REVISION RESPONSE LETTER

**RE: LOT 13
Site Development Plan
File Number PPR 18-044**

DATE: December 3, 2018

5 DRIVEWAY DETAIL NOT TO SCALE

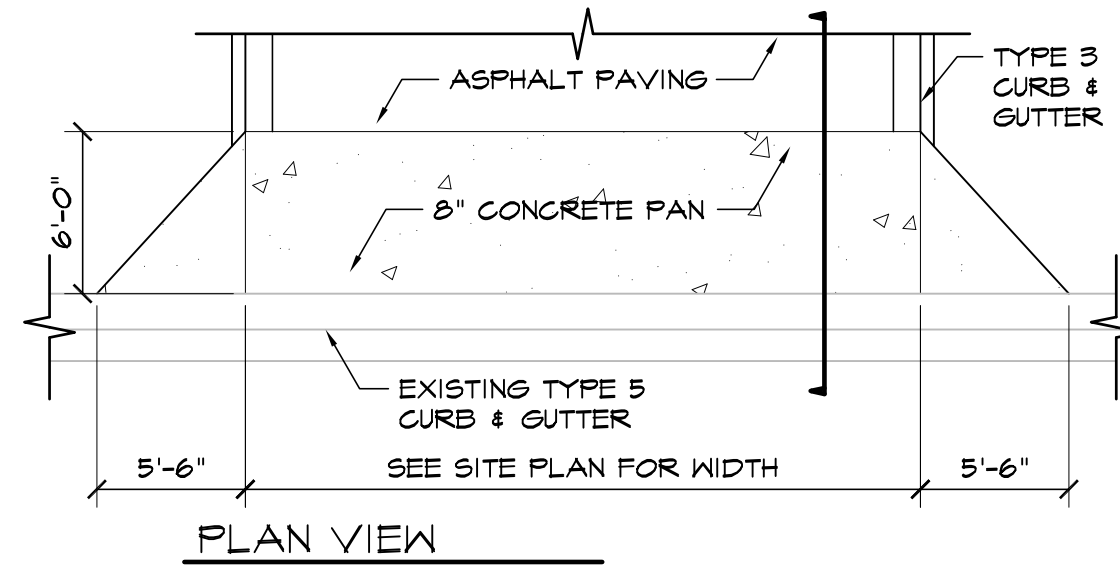
- *Include ADA route and note*
 - **ADA exhibit and note was added**
- *Revise driveway detail to El pas county standard detail*
 - **This is the detail we have used for all of the Claremont business park projects. We have been using this since 2006 without any issues. In addition, the detail is applied to a private road so this should not be an issue to remain as is.**

1 SITE PLAN SCALE: 1"=20'-0"

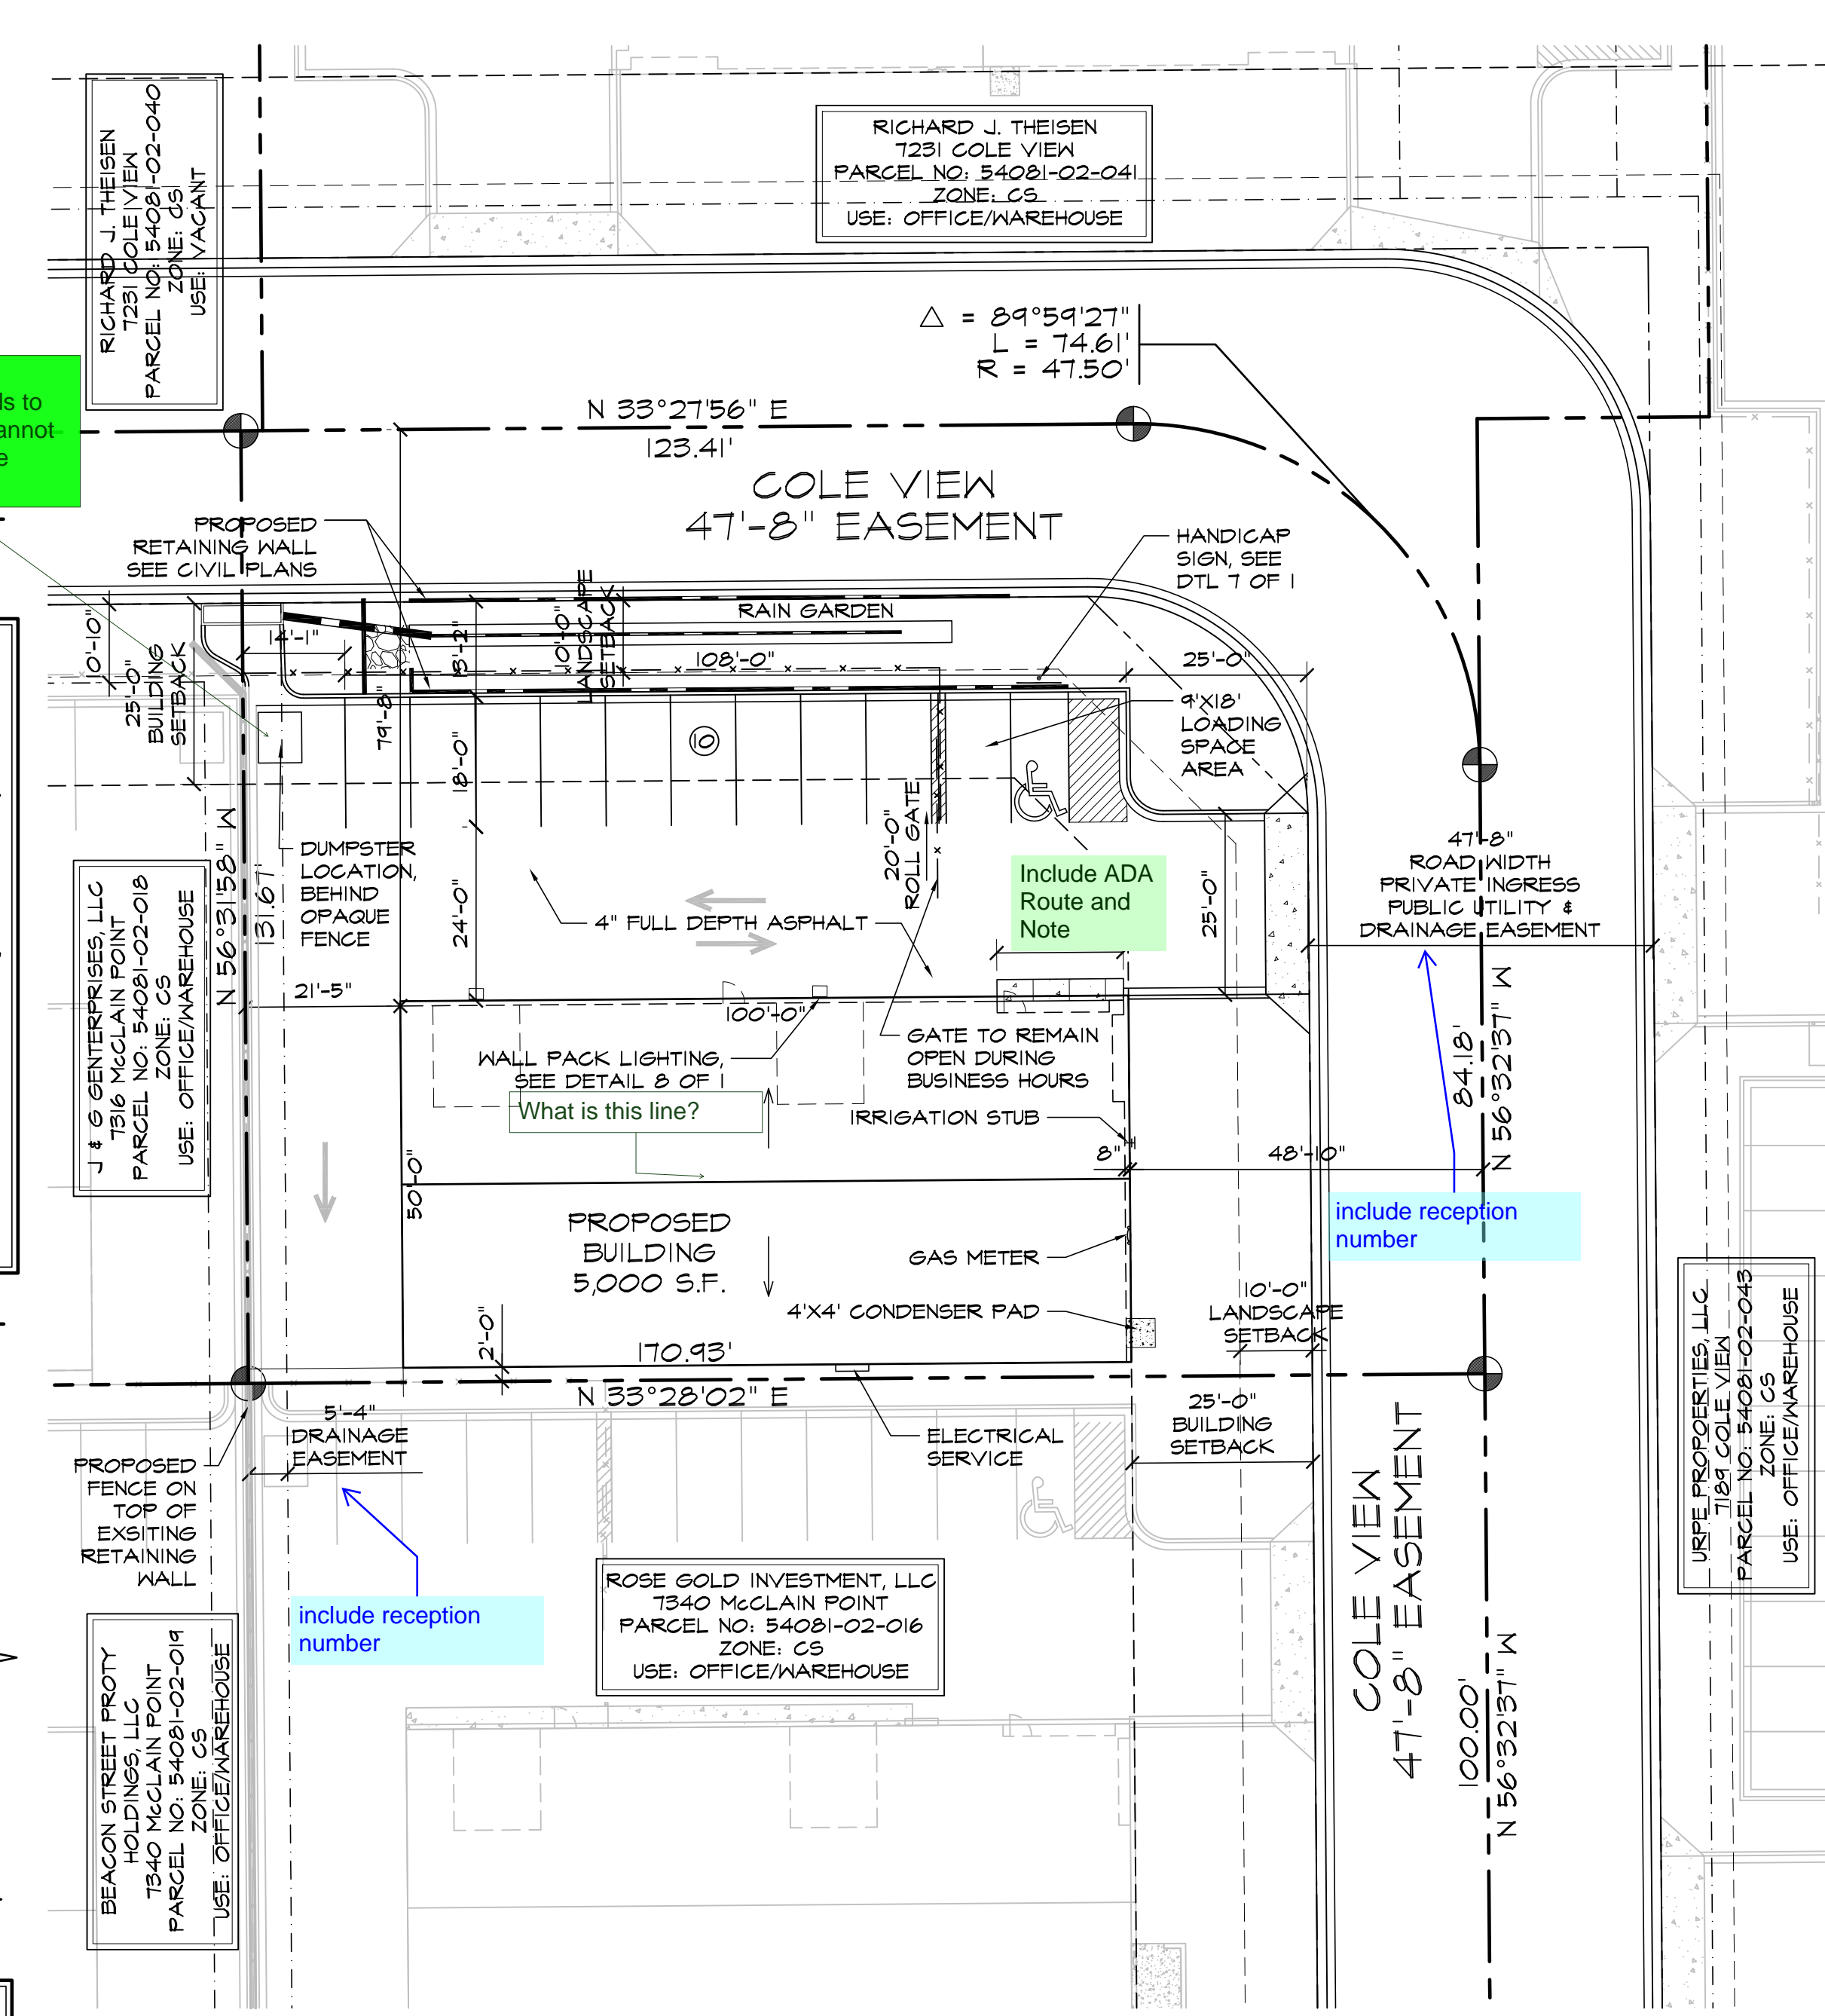
- *PCD file number*
 - **PCD number was added to site**
- *Include reception number*
 - **Reception number was added to drainage easements**
- *Show detail of dumpster, needs to be screened, cannot be in a drainage easement*

- **Dumpster location was removed, there will be no trash enclosure on the site. Any trash being generated will be disposed of by the owner. The owner will take this trash with them to dispose of properly themselves.**
